APPLICATION TO MAKE A NON-MATERIAL CHANGE
TO THE FOLLOWING DEVELOPMENT CONSENT ORDER:
The A14 Cambridge to Huntingdon Improvement Scheme Development
Consent Order 2016 (SI 2016 No 547) (as corrected by the A14
Cambridge to Huntingdon Improvement Scheme Development Consent
(Correction) Order 2017 (SI 2017/1121))

**The A14 Cambridge to Huntingdon Improvement Scheme
Development Consent (Amendment) Order 2019**

Drawing file: TR010018 / TR010018-000445-A14 2.05 Rights of Way and Access Plan-Sheet 10 of 28.pdf

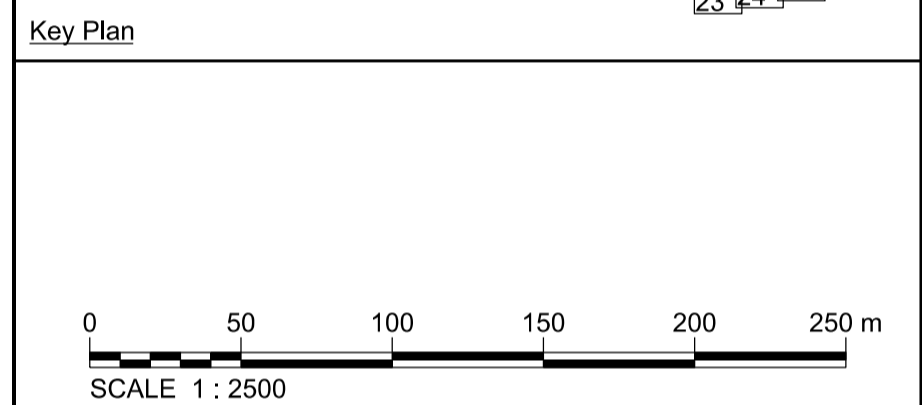
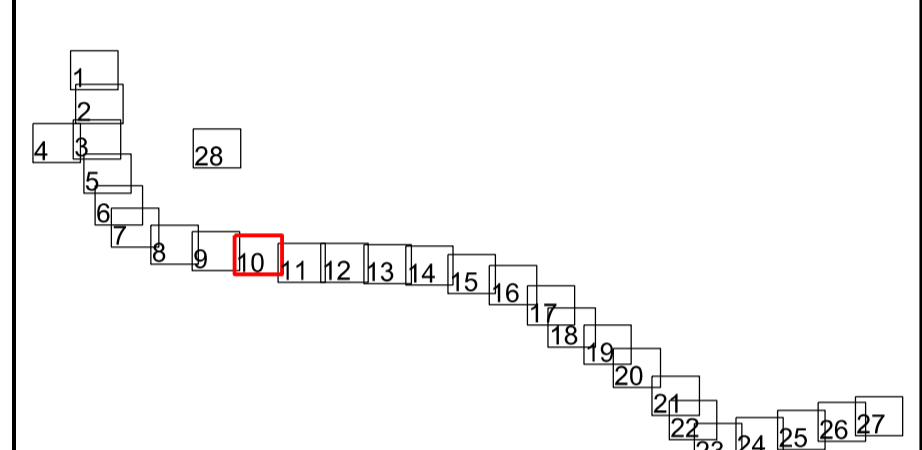
- (b) under the heading “The rights of way and access plans – sheet 5” in the third row for the entry in column (4) substitute—

“Reference B

To be substituted by a new bridleway between bridleway Reference E (on sheet 3), generally in a north-west direction, then turning south westward to pass under the new A14(M), then turning generally south-eastwards and south along the west side of the A1(M) to existing Park Road (on sheet 6) for a distance of 1990 metres (for continuation of Reference B see sheets 3 and 6).”.

Drawing file: TR010018 / TR010018-000612-A14 2.10 Traffic Regulation Measures Plan-CWL-Sheet 04 of 36.pdf

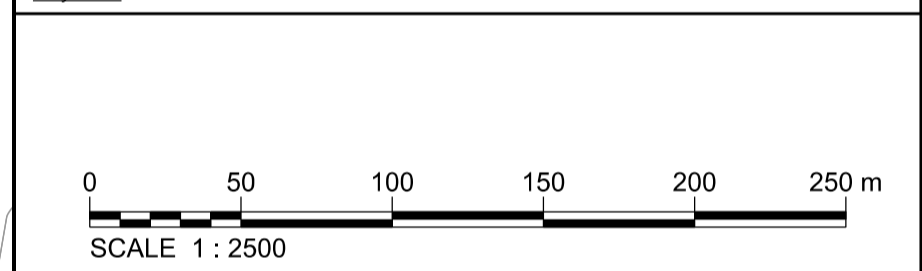
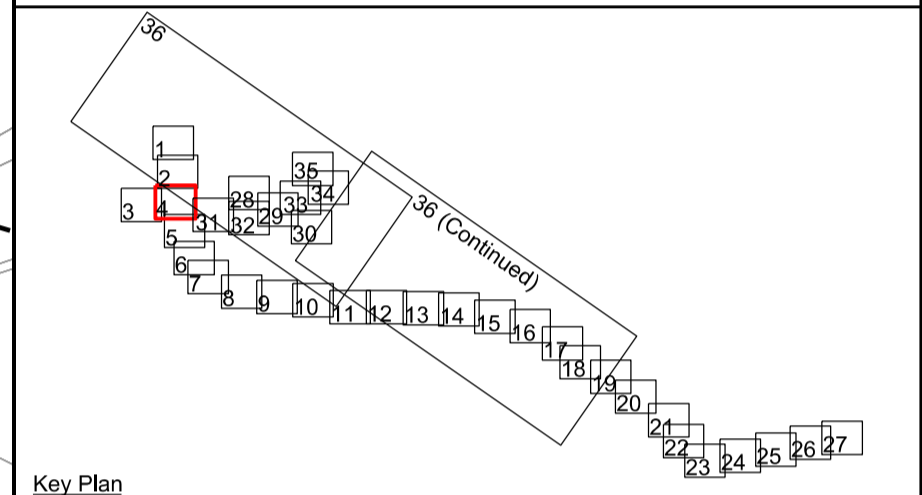
- (a) in the heading “The traffic regulation measures (clearways and weight limits) plans – sheets 3, 4, 5, 6, 7, 8, 9, 10, 11, 12, 13, 14, 15, 16, 17, 18, 19, 20, 21, 22, 23 and 24” for “sheets” to the end substitute “sheets 3, 4 and 5”;
- (b) under the heading referred to in paragraph (a)—
 - (i) in column (1) omit from “Buckden” to the end; and
 - (ii) in column (2) for “including” to the end substitute “to the junctions with the new merge and diverge slip roads to the Northern and Southern New Ellington roundabouts”;
- (c) under the heading “The traffic regulation measures (clearways and weight limits) plans – sheet 4” after the entries in columns (2) and (3) respectively insert—

“A14 Trunk Road Eastbound diverge slip road onto the Northern New Ellington Roundabout.	“Clearway (to include verges, hard shoulders, slip roads and laybys).
A14 Trunk Road Westbound merge slip road from the Southern New Ellington Roundabout.”	Clearway (to include verges, hard shoulders, slip roads and laybys).”;

Drawing file: TR010018 / TR010018-000625-A14 2.10 Traffic Regulation Measures Plan-CWL-Sheet 17 of 36.pdf

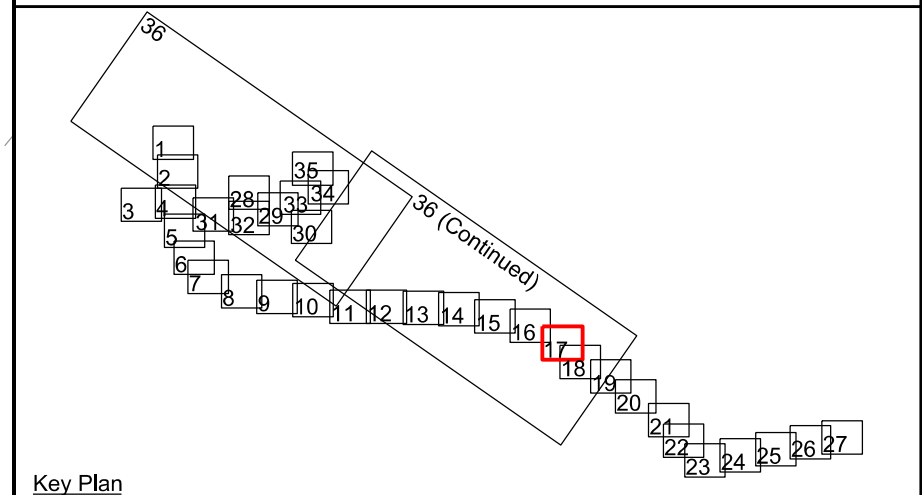
- (e) under the heading “The traffic regulation measures (speed limits and prohibitions) plans – sheet 17”—
 - (i) in the first row in column (2) after “113” insert “metres”;

- (ii) in the fifth row omit the entries in columns (1) to (3);
 - (iii) in the sixth row omit the entries in columns (2) and (3);
 - (iv) in the seventh row omit the entries in columns (1) to (3);
